1518-1526 Stittsville Main St – Site Plan Application Construction Management

RE: 1518-1526 Stittsville Main St – Site Plan Application Construction Management Plan

Site Plan Application Construction Management Plan

Dated: April 1st, 2024

Drawing Title: SITE SERVICING, SEDIMENT & EROSION CONTROL PLAN

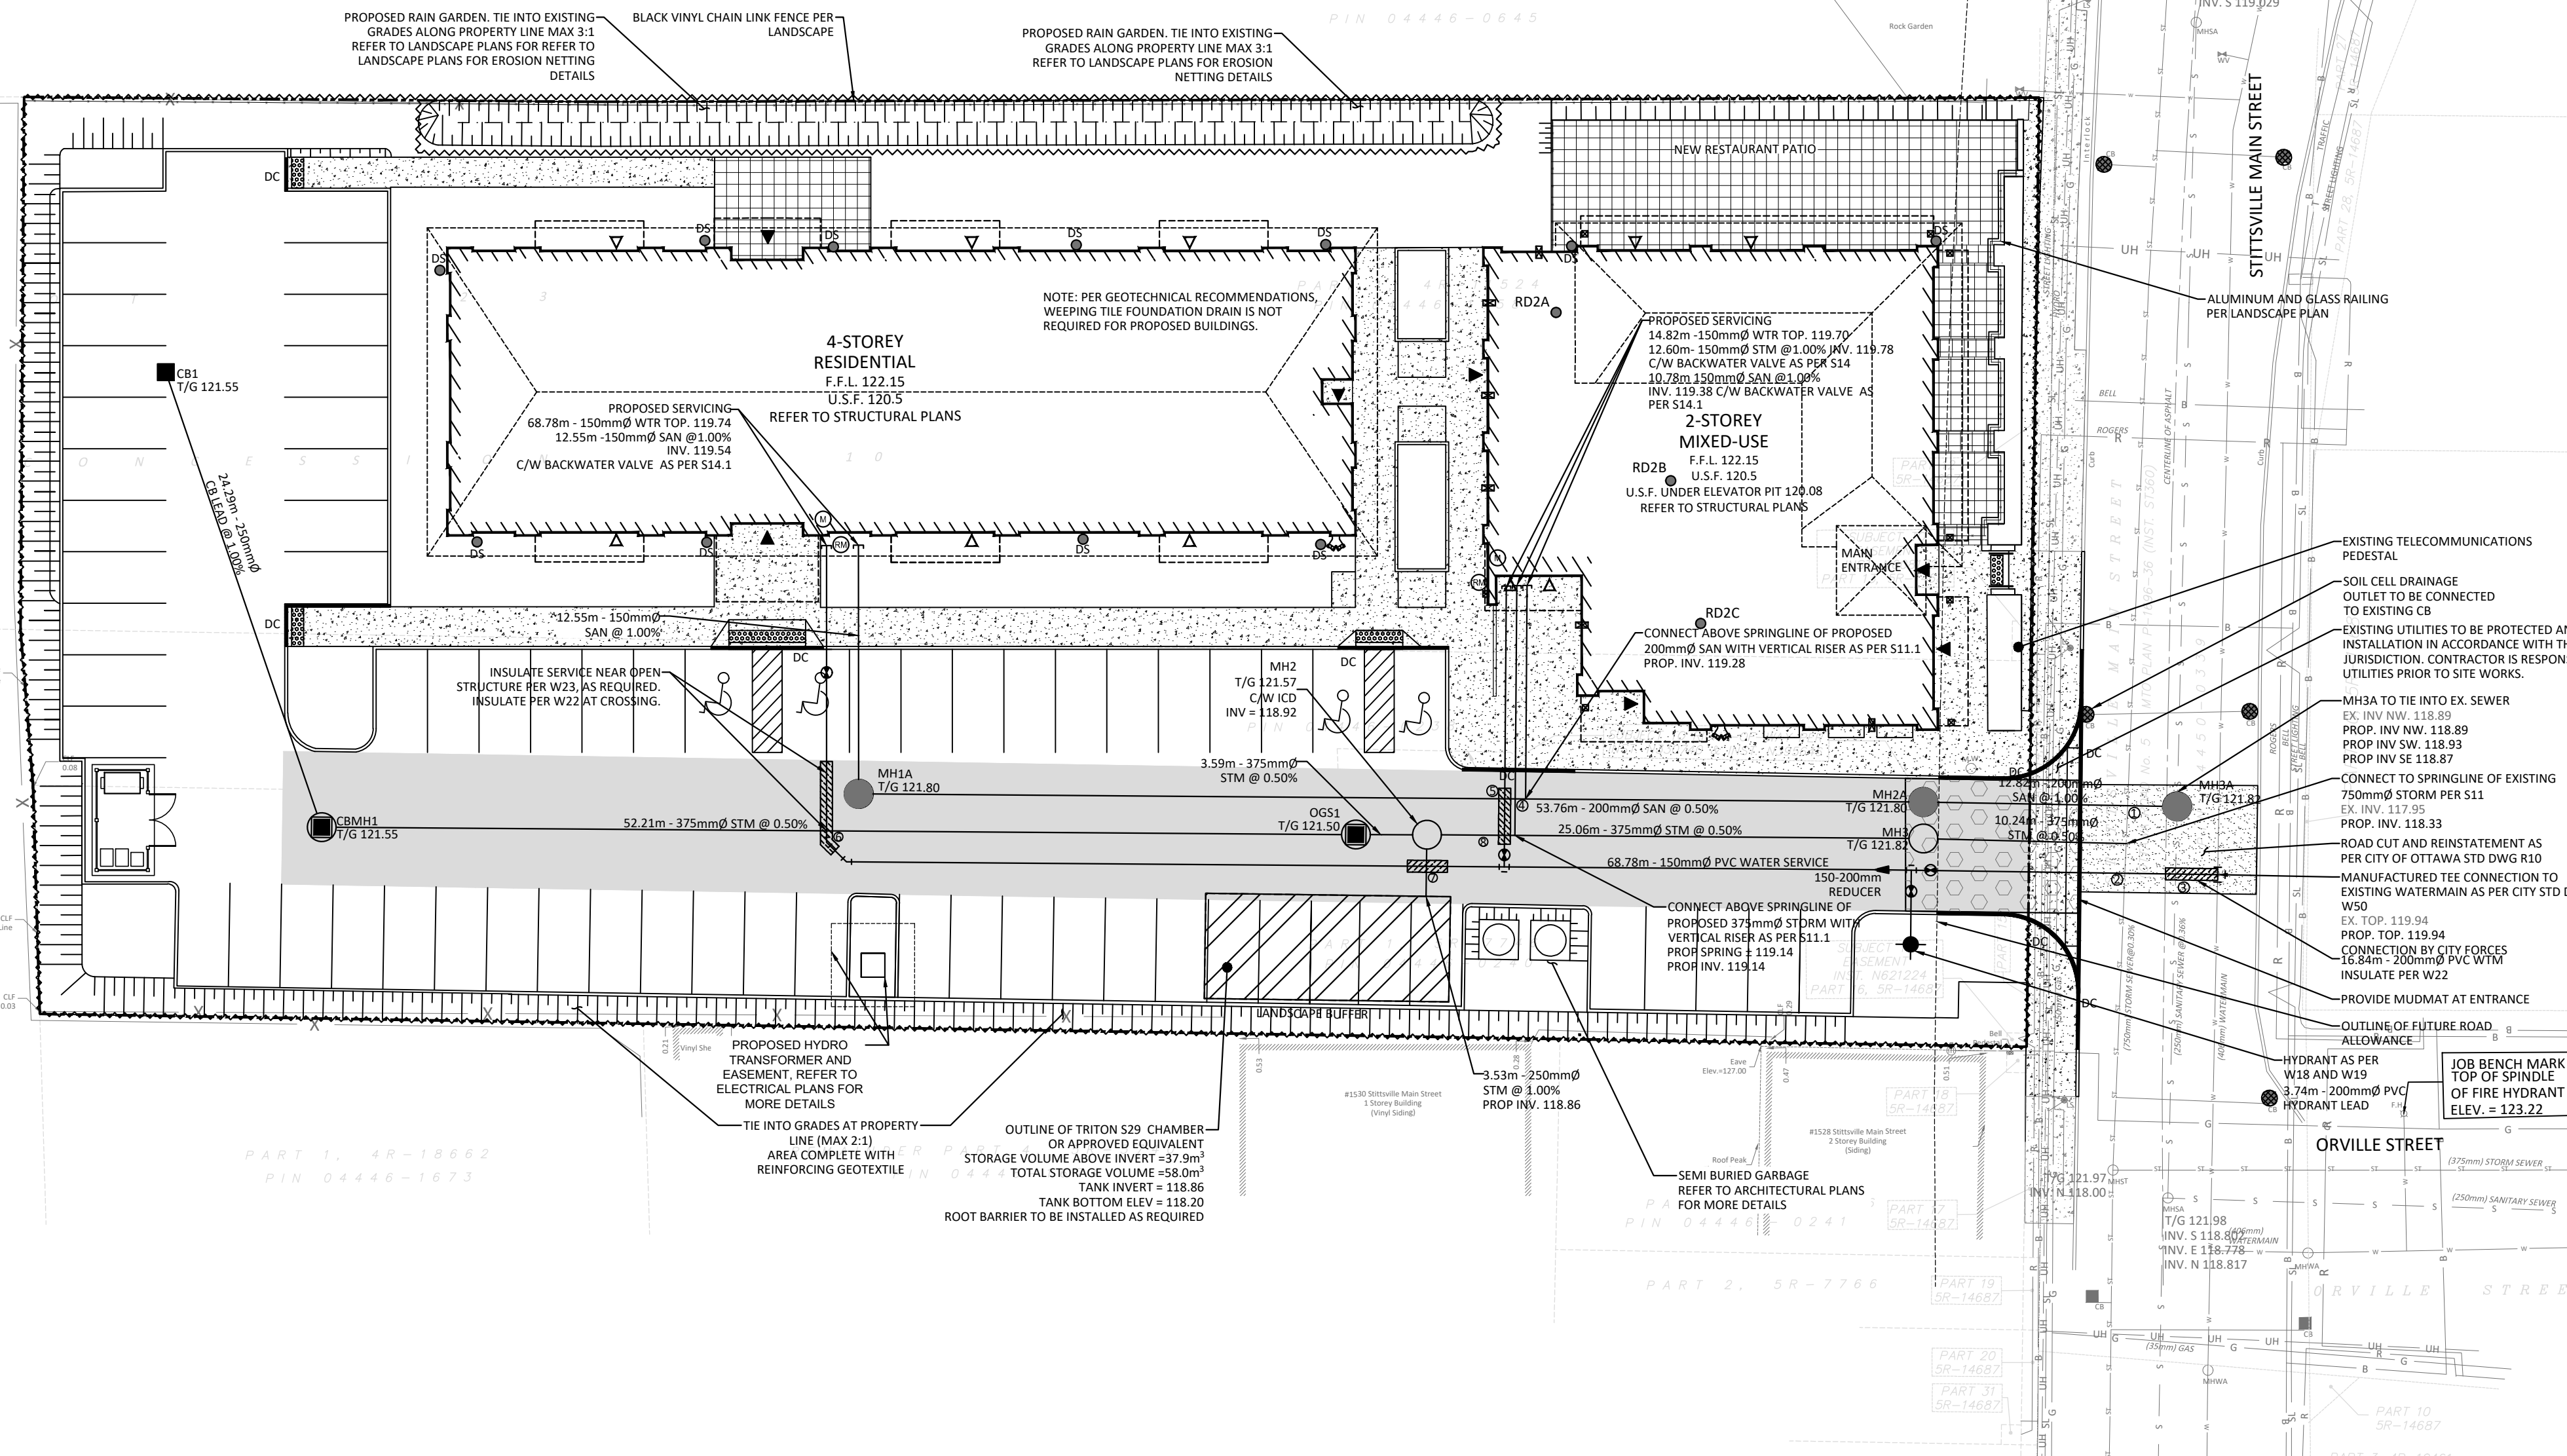
132 (b) Will there need to be site servicing/road cut impacts? – this needs to also have a dimensioned site plan and TCP to show the impact.

a. IH Response: For the majority of construction, our temporary site fencing will be installed within our property limits. At this time, the only road closure requirement would be to connect the site services to the main hydro, Enbridge gas, water, sewer and storm services. Inverness's sub-contractor will apply for a road cut permit and outline the road closure durations along with the proposed traffic control measures at the time of the road cut permit application. We anticipate that the road closure permit would only be required during day time hours for a 5 day period. Steel plate will be installed after hours to allow traffic to flow normally after regular working hours. Please see the above site plan outlining the proposed new service locations.
